**WELWYN HATFIELD COUNCIL – DEVELOPMENT CONTROL**  
**DELEGATED REPORT**

<b>APPLICATION No:</b>	<b>S6/2008/1774/FP</b>
------------------------	------------------------

Proposed Side Elevation

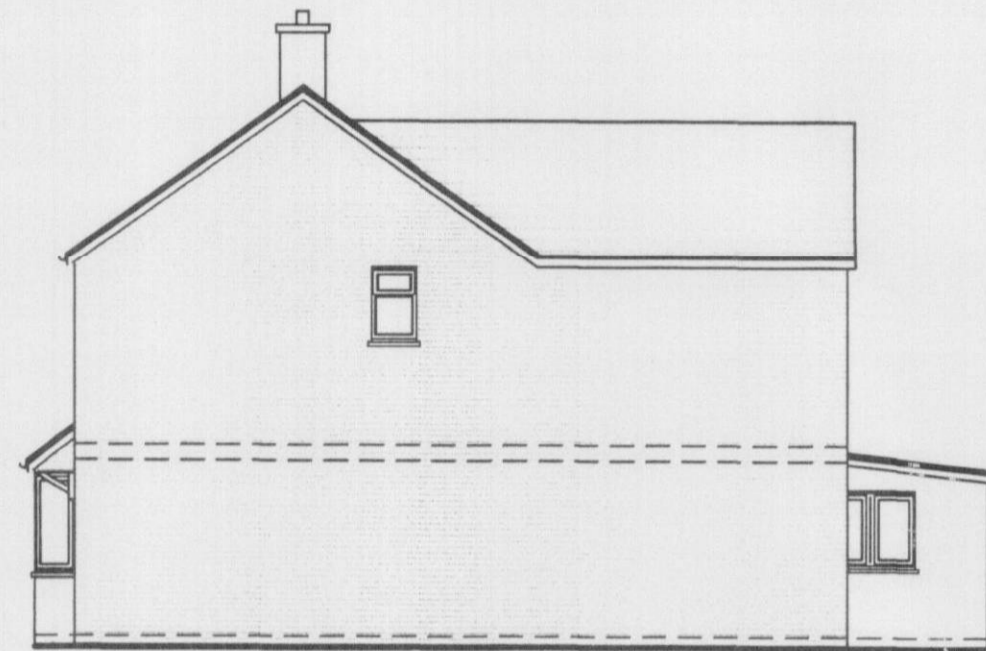
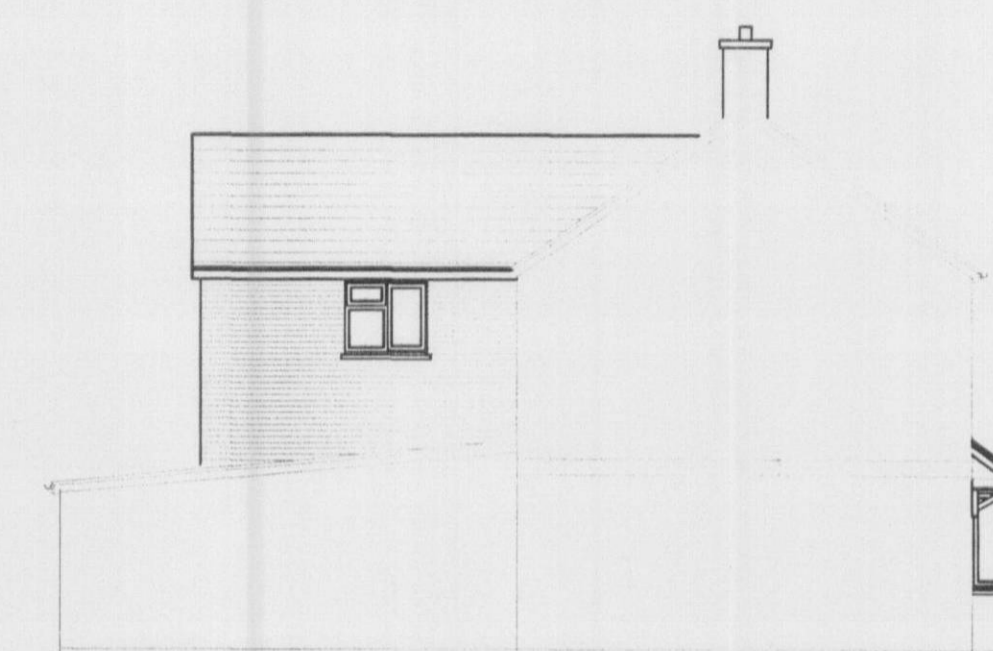
1. The proposal would, by virtue of the depth and close proximity of the new flank wall to the existing Public Footpath, result in a form of development which would be harmful to the visual amenity of the square and users of the footpath. The development has therefore failed to reflect and respond appropriately to its surroundings, thereby creating a visually intrusive form of development out of keeping with and detrimental to the character and appearance of the square and public footpath. The proposal is thereby contrary to Policy D1 and D2 of the Welwyn Hatfield District Plan 2005 and the Supplementary Design Guidance February 2005 and National Planning Policy PPS1 and East of England 2008 Policy ENV7.
